**Planning Application Ref:** FG/217/21/T

**Location:** 1 Sea Lane Close, Ferring, BN12 5DT

**Description of works:** 1no. *macrocarpa* tree (T1)- Remove damaged major lower N/E limb back to trunk. Reduce lower northern limb by 3m to give adequate distance from highway. Reduce radial spread by 2m, reduce overall spread from 14m to 10m. Crown lift to 5m. Deadwood canopy and remove any damaged branches.

T1

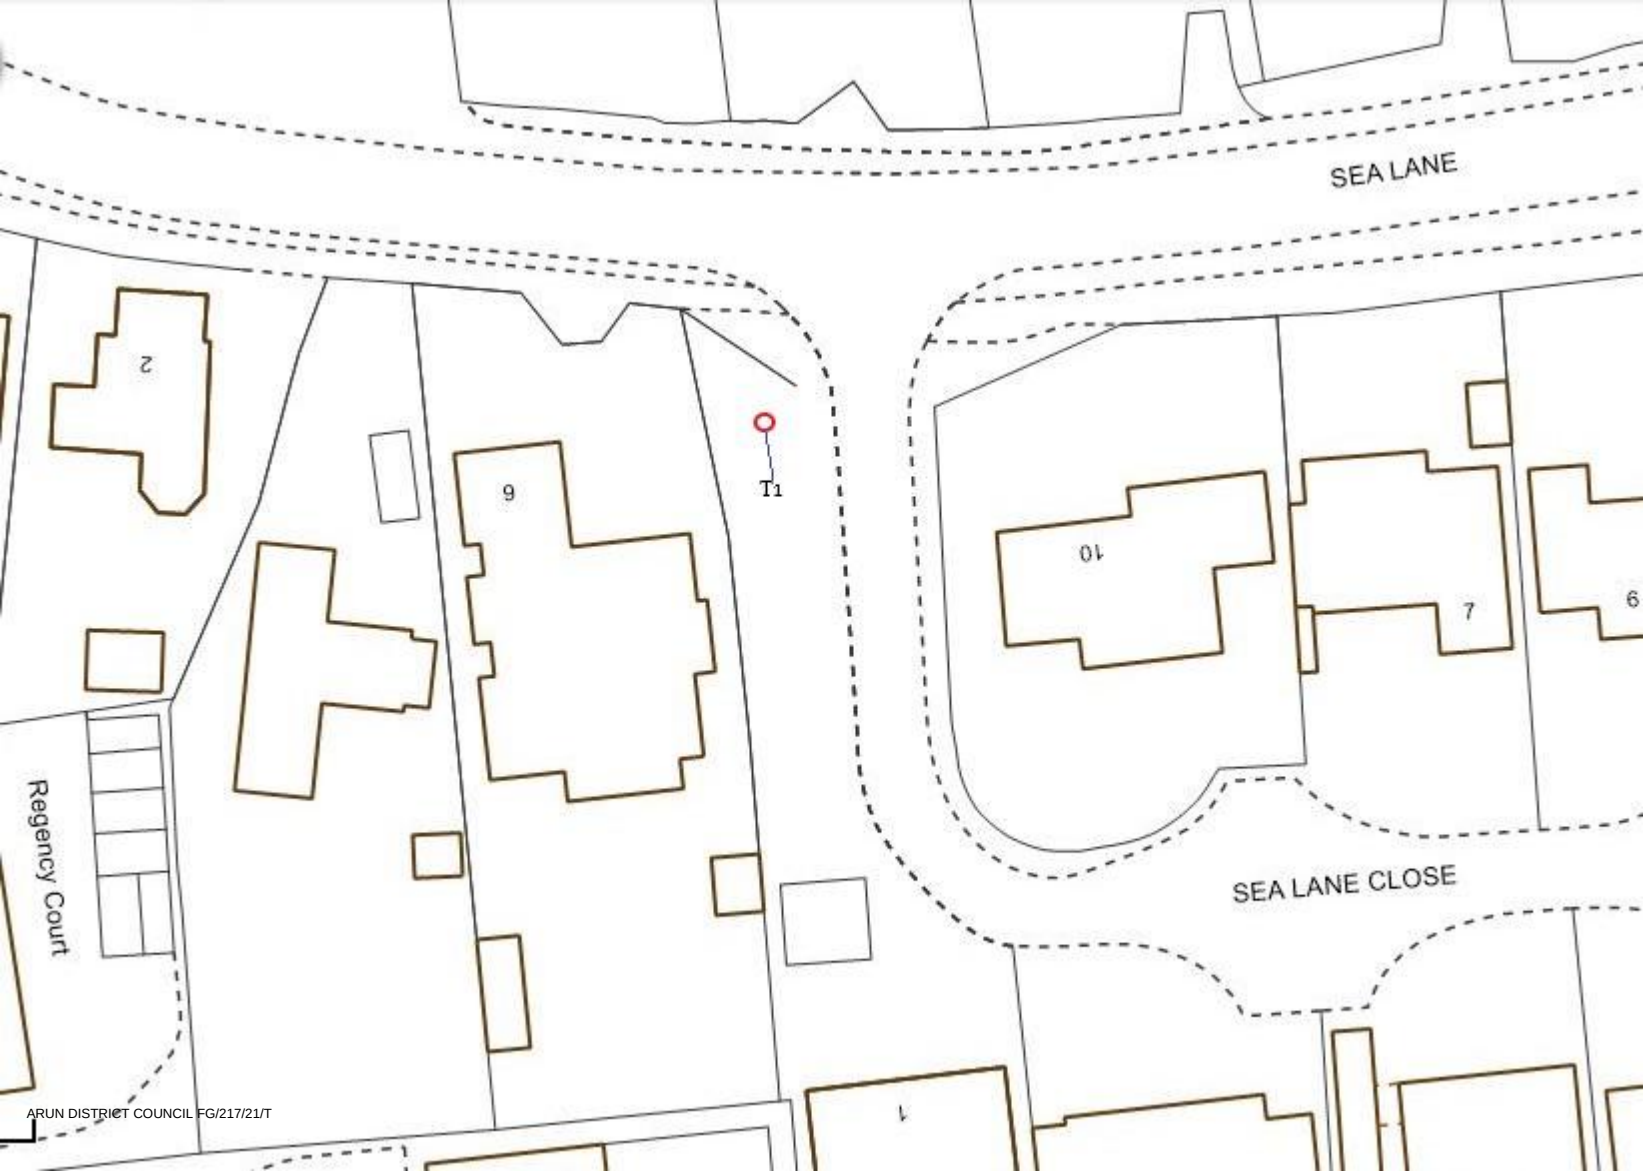
- We can accept this application as due notification of appropriate and limited work to deal with any imminently dangerous crown material such as reported on the lower NE limb.

- The work proposal also seeks to reduce crown spread on all aspects by 2metres, raise crown height to provide 5metres overhead clearance on all aspects, reduce large limbs to mitigate risk of impact from vehicles and prevent failure. Collectively this represents a significant amount of live material to be removed.

- This tree requires careful management that respects its age and vulnerability to environmental changes and disease progression.
- The removal of low branches to achieve 5m clearance above ground level on all aspects has not been justified on arboricultural grounds and exceeds that which is recommended in the British Standard (BS3998:2010) Tree work – Recommendations.
- Adequate clearance of public highway and removal of hazardous material can be achieved by undertaking limited works under the exception described above.
- Whole crown reduction pruning has not been justified on arboricultural grounds in my opinion. The extent of property and public highway overhang is not obviously problematic where adequate overhead clearance exists and it contributes to visual amenity.

- The tree is a significant feature in the local landscape and appears to be in adequately sound and healthy condition. Elements of tree surgery within the proposal that do not qualify as an exception would result in excessive reduction of the tree's landscape impact and undue detriment to the visual amenities of the locality.

- I recommend **REFUSAL** for this application.
